From: Tim Townsend [REDACTED]
Sent: 27 November 2017 09:41
To: Planning.Responses
Cc: Richard Temple; Darryl Hemmings; Caroline West; Derek Whittington
Subject: AL/115/17/OUT - Outline applicaiton with some matters resevred for 55 homes - Land at Wings Nursery, Lidsey Road, Woodgate - WSCC highways and transport response dated 27th November 2017

**WEST SUSSEX COUNTY COUNCIL
PLANNING SERVICES CONSULTATION**

SUBJECT: AL/115/17/OUT - Outline application with some matters reserved for the erection of 55No. dwellings, sustainable drainage measures, public open space, children's play area, landscaping & all other associated works. This application is a Departure from the Development Plan.

LOCATION: Wings Nursery, Lidsey Road, Aldingbourne, PO20 3SU.

RGP Swept Path Analysis

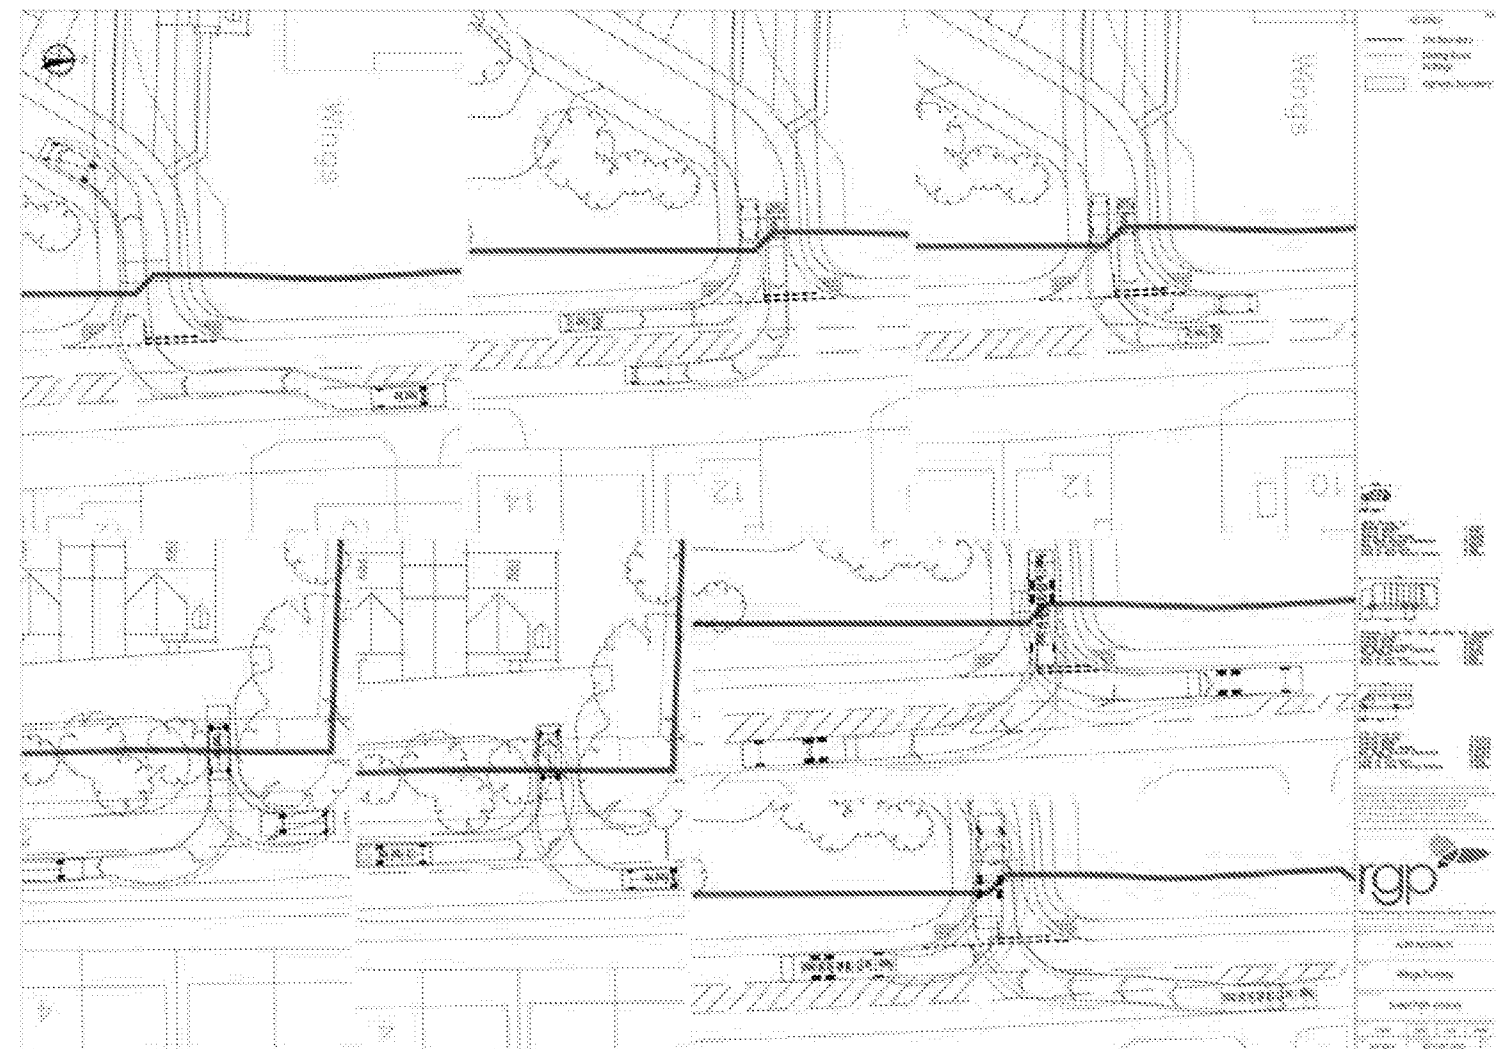
The Highway Authority has reviewed the information provided (including swept-path diagrams of vehicles entering and leaving the junction). Based on that provided, three concerns have been identified. Namely:

2. Large vehicles are required to oversail the centreline of the new access road. If they attempt to do this during busy period when traffic might be blocked because of the queueing extending back from the railway crossing, such vehicles could end-up finding their paths blocked, thereby leading to potential blocking on the A29.
